RESPONSE TO SUBMISSIONS REPORT

SSD 34919690 – MOD 2
39-43 HASSALL ST PARRAMATTA

APRIL 2025

Level 7

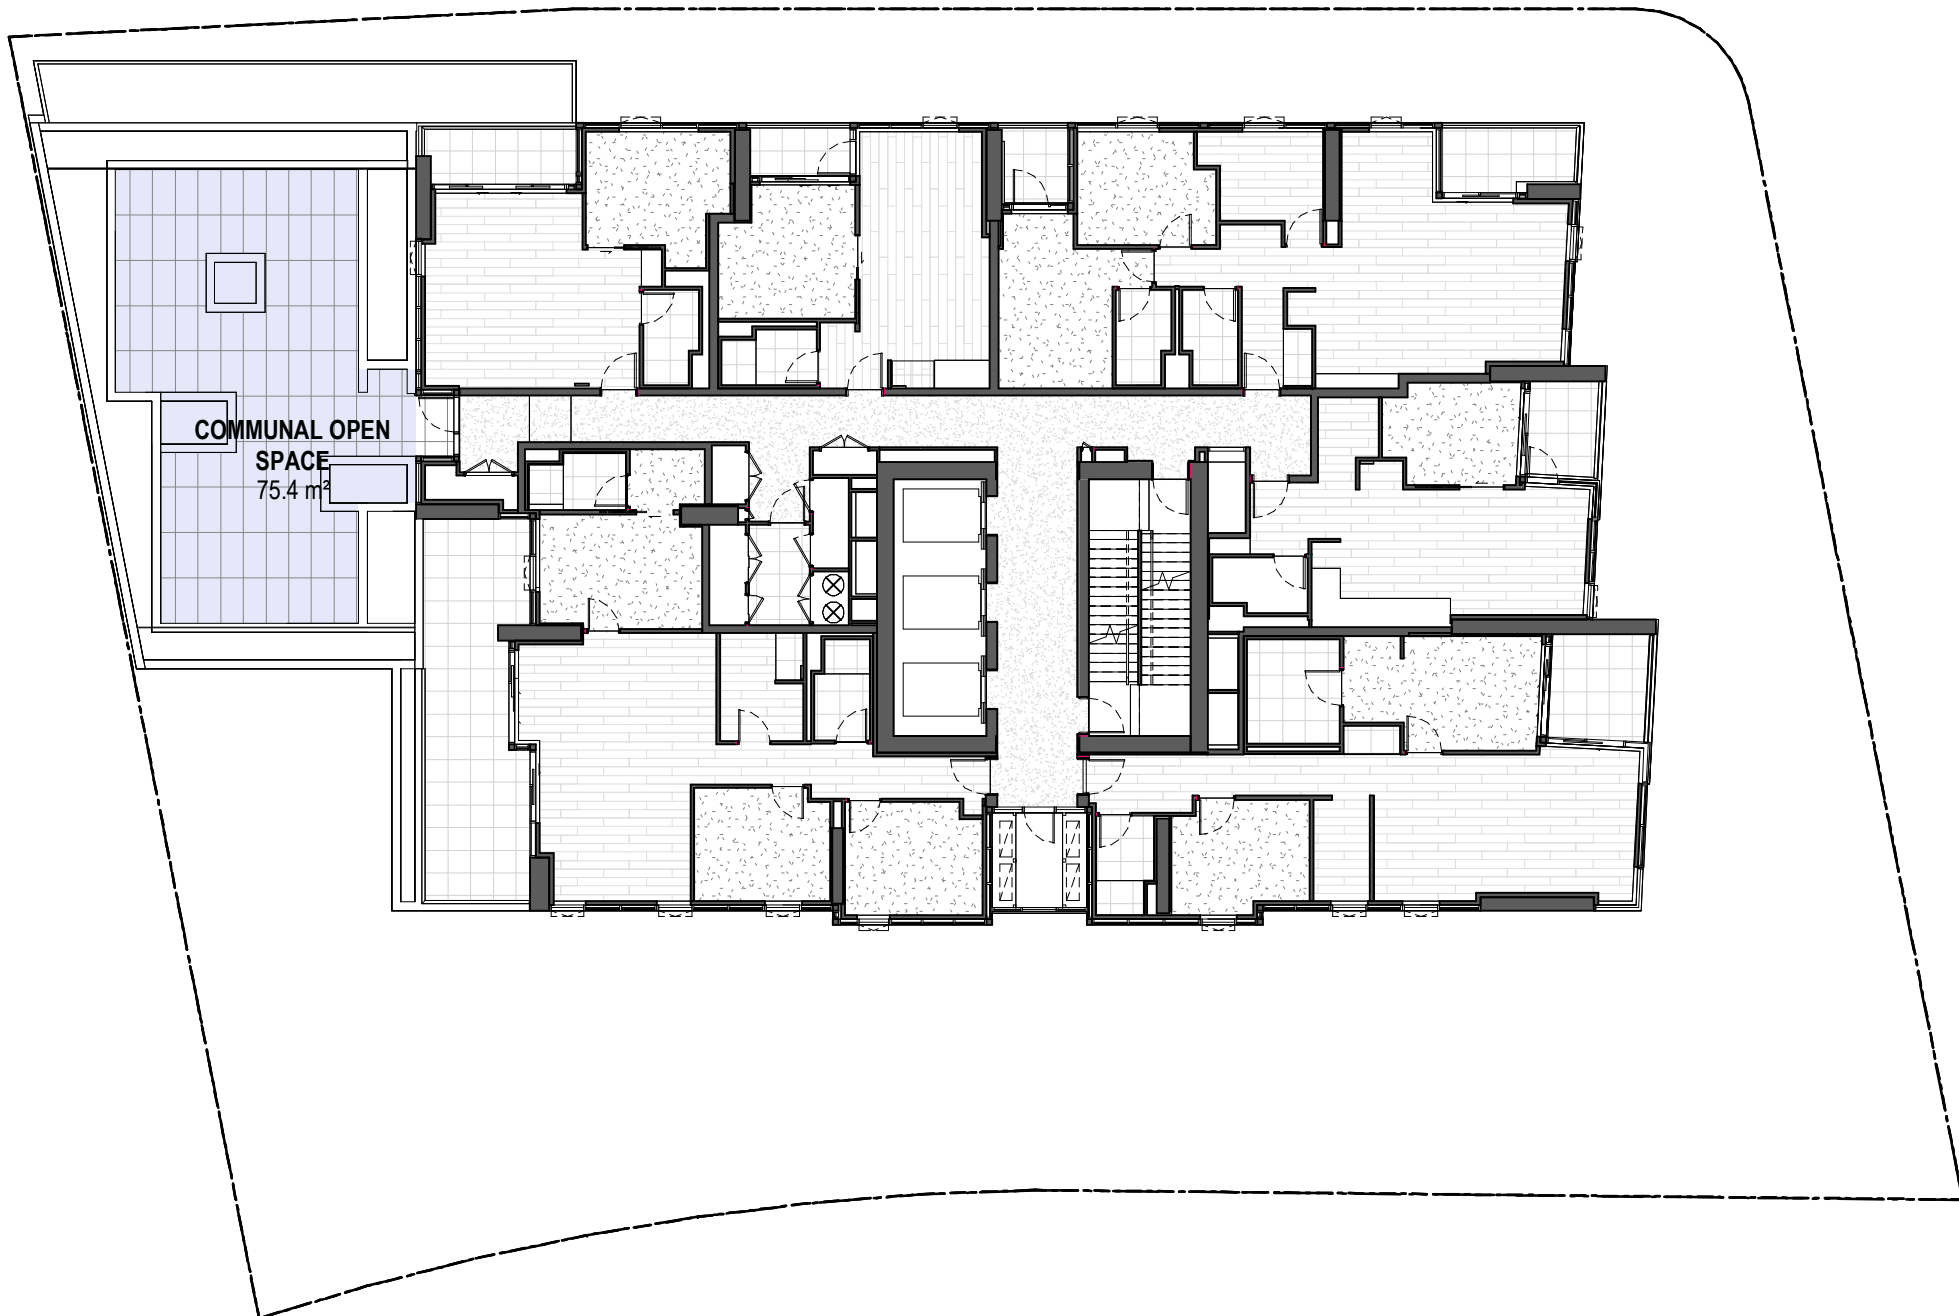
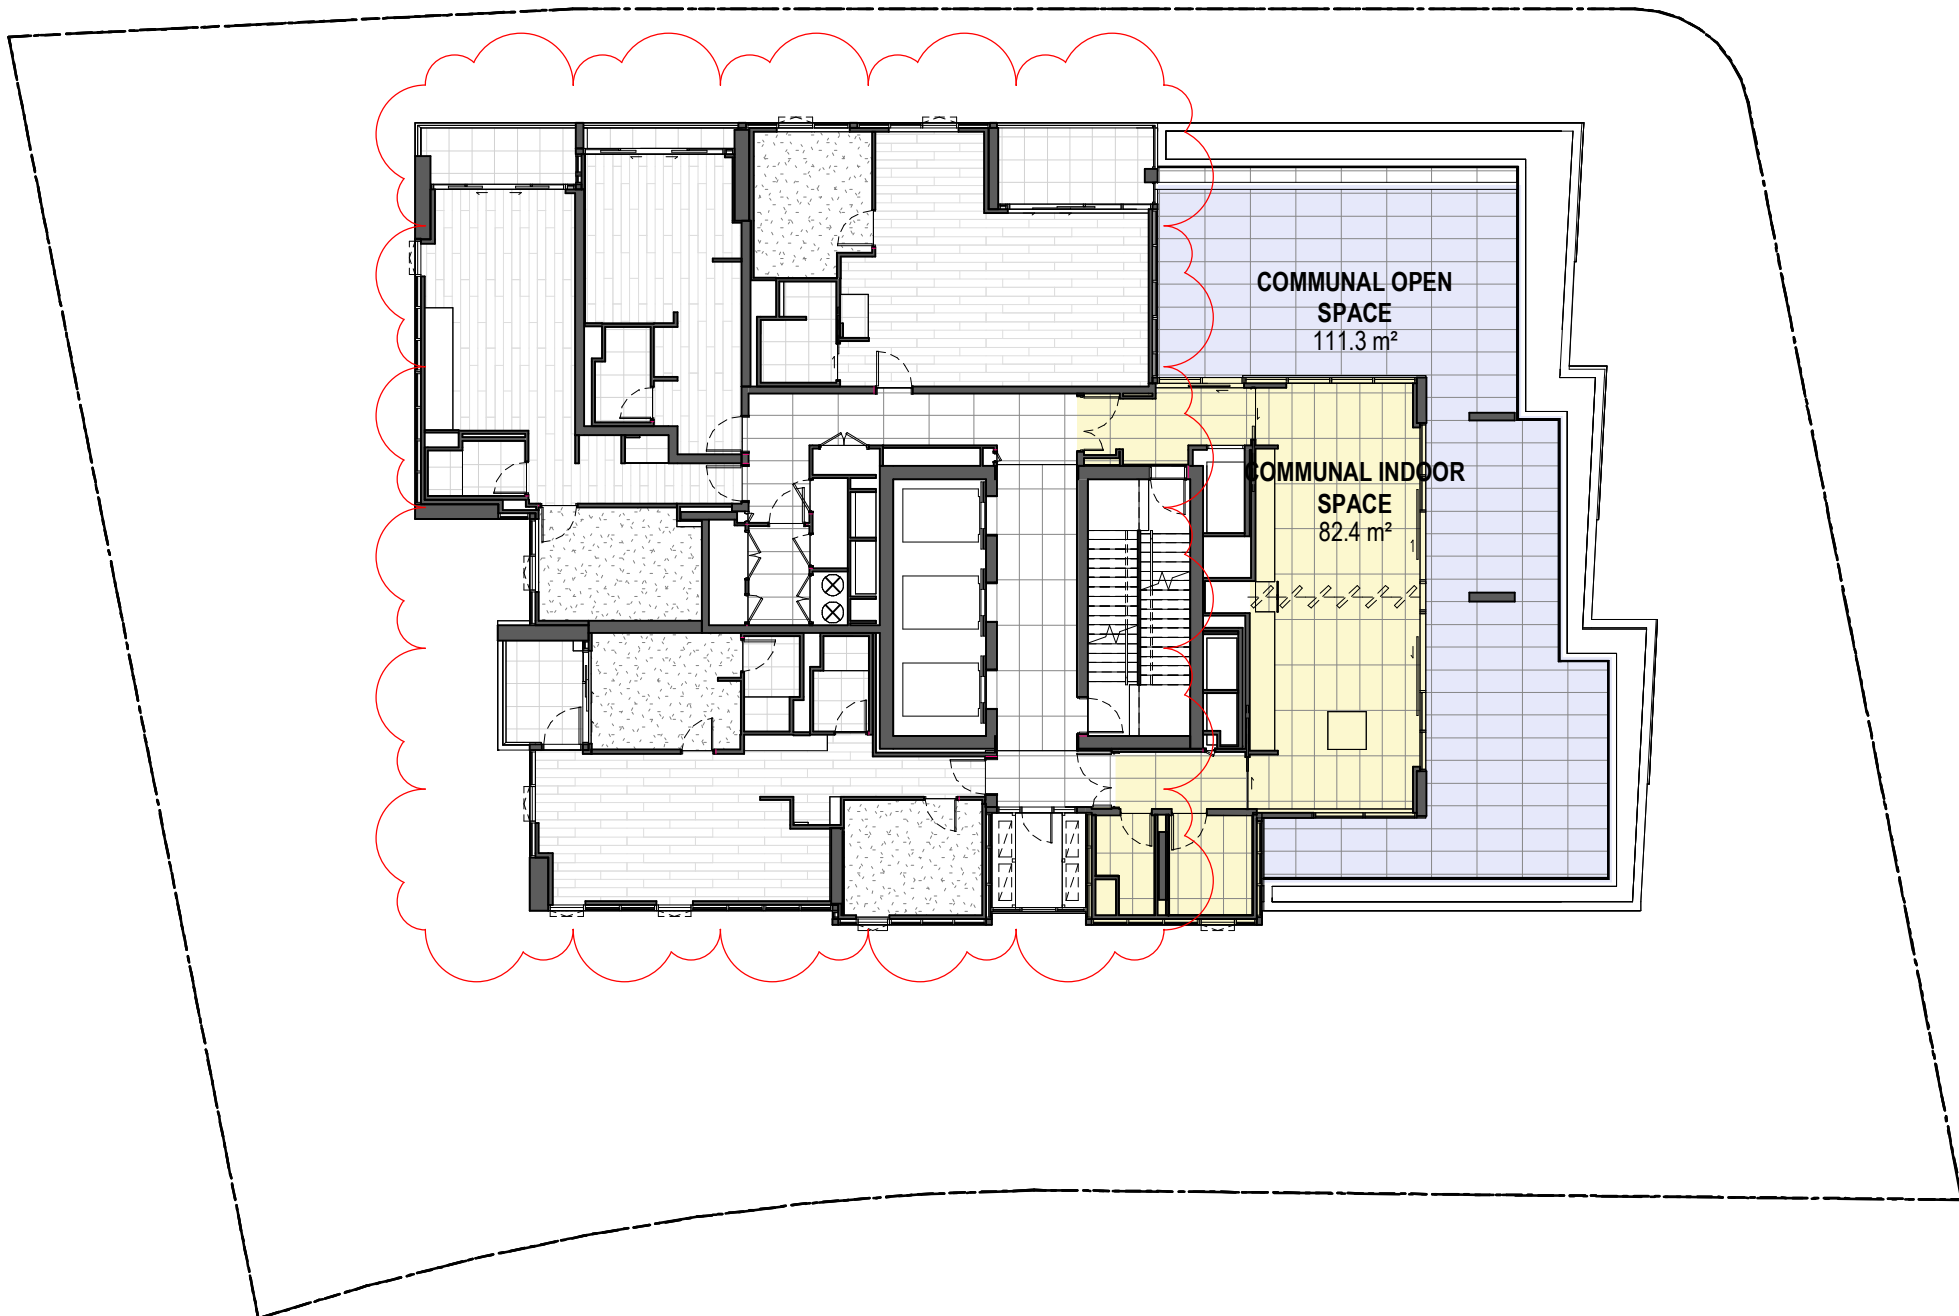
COP 2	• Council has reviewed the revised landscape report for the modification application and raised concern over the location of 4 x Tristaniopsis laurina (Watergum) trees, at ground level, that are shown to only be planted between 0.45-0.5m away from the approved building. This is not considered to be ideal. The proximity to the building means the trees will clash with the building façade, causing on-going building maintenance issues. Constant pruning will be required, resulting in the poor form, structure and overall decline of the proposed trees. The likely outcome of this will be the eventual removal of the trees from the site.	The Tristaniopsis laurina (Watergum) trees have been relocated 3m away from the building line as part of this amended proposal. Trees were conflicting with surface stormwater pipes have been removed.
COP 3	• Section B of the application's accompanying landscape report incorrectly illustrates the location of Tristaniopsis laurina and shows the tree as clashing with the building façade	The landscape plan has been amended to have to be consistent with the architectural plans with no clashing of the building façade.
